**OBJECTION TO THE OBERON WHITE GRANITE QUARRY (APPLICATION 07\_0122)**

# Oberon White Granite Quarry Review of EAR

Oberon White Granite Quarry  
Ferndale Road

Submitted to  
Department of Planning  
On Behalf of Lawndock Pty Ltd

Figure 9 - View Catchment and potentially affected residences

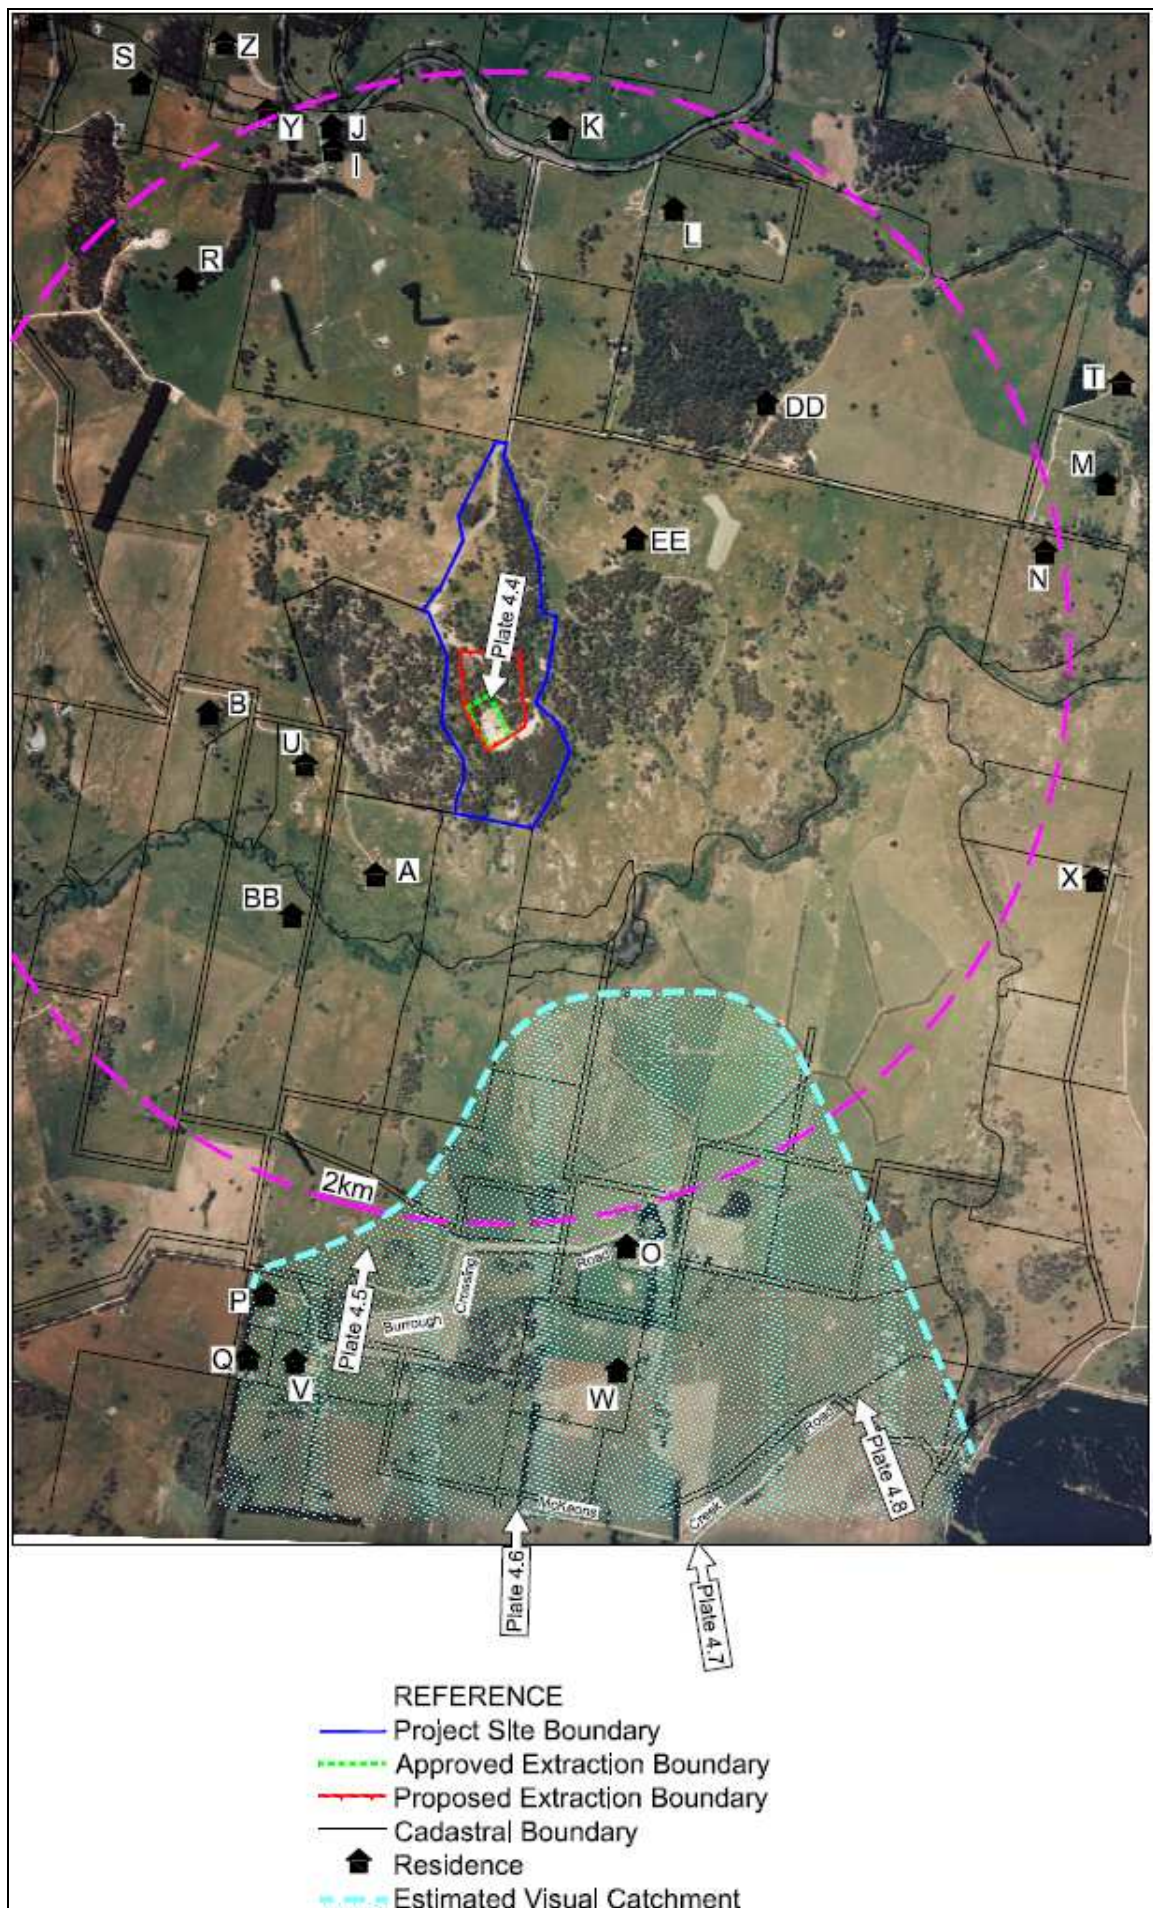
- The visual impact assessment has not carried out any visual impact assessment of the quarry from the Lawndock property, and in particular from the existing residence on the Lawndock property, or from the proposed dwellings sites as part of the approved Lawndock subdivision (in particular dwellings located at Lot 1, Lot 2 and Lot 3). Further visual impact assessment

is considered necessary to clearly determine the level of visual impact to the Lawndock property, its existing residence, and its approved residential dwellings.

The quarry is highly visible from a large part of the Lawndock property. We have carried out a preliminary consideration of the particularly sensitive locations on the Lawndock property, including the current level of impact and the possible future visual impact. There are four locations where we have reviewed the potential visual impact. These four locations are shown in Figure 1, and include the existing residence, the proposed dwelling envelope locations for the approved subdivision as well as from a particularly affected part of the property.

Given the currently highly visible nature of the quarry and the lack of meaningful mitigation measures proposed, Lawndock requests that the Department of Planning require a more robust assessment of visual impacts to be undertaken by the proponent, with a view to determining the actual visual amenity impacts of the expanded quarry.
